**Re:** Railway works and all works necessary to eliminate and, where necessary, upgrade seven numbered level crossings and carry out all associated and ancillary works along a 24-kilometre section of the Dublin to Cork Railway Line.  
Fantstown, Thomastown, Ballyhay, Newtown, Ballycoskery (Ballyhea Village), Shinanagh and Buttevant, Co. Cork and Co. Limerick.

Re: Application by Córas Iompair Éireann for a Railway Order. ABP- Case reference:  
NC04.305149

As a Dáil Deputy for the Constituency of Limerick County and representative of the community of Effin, I would like to make a submission in respect of the proposed removal and closure of a level crossing at Thomastown, Co. Limerick (public reference XC201).

Figure 2.5: XC201 Thomastown Proposed Route Alignment

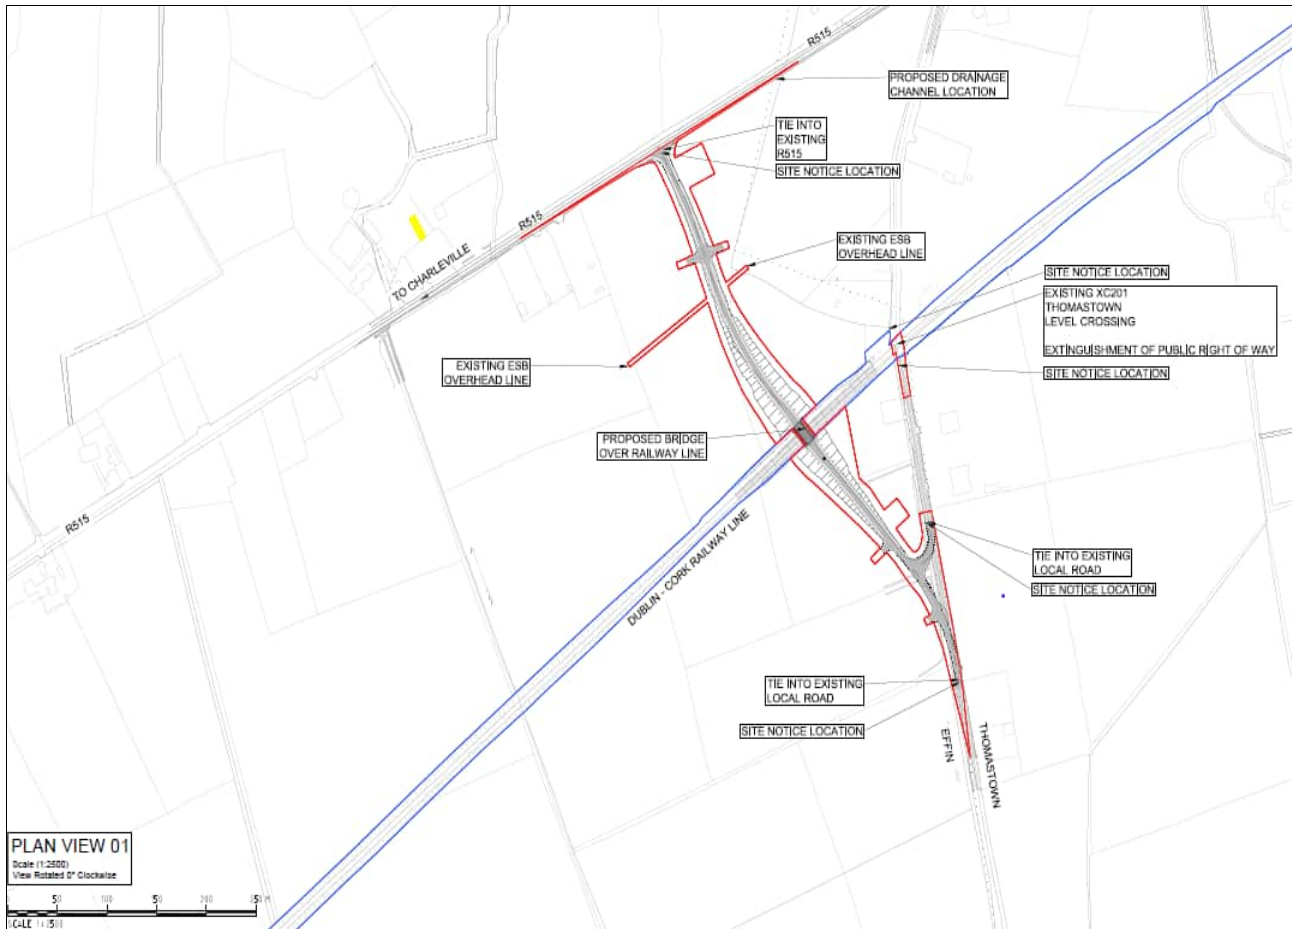
Having met residents that live along, and adjacent to the R515, they have laid out a very clear case for the need for a stacking/turning lane for right hand turning traffic off of the R515. They do so with the daily knowledge they have gained over years of trying to turn right off of the R515 at the existing junctions that are along the road and point to the fact that as this is a new junction, and with growth in traffic clearly being established, the need for a right hand lane at the junction is clear.

The residents have again expressed their concern at the proposed width of the road from the proposed new junction with R515 to the new bridge over the rail and have asked that the proposed road be widened to allow at least two vehicles to pass. They have also asked that the Board would take into consideration the agricultural backdrop and setting of the area and the heavy nature of the vehicles that will be likely to use this road. Again they point out that this will be a once off opportunity to improve the road safety aspect for the community of Effin and they would like to ensure that the proposed width is not designed in a way that will hamper its use in the future and render it unsafe for two vehicles attempting to pass each other.
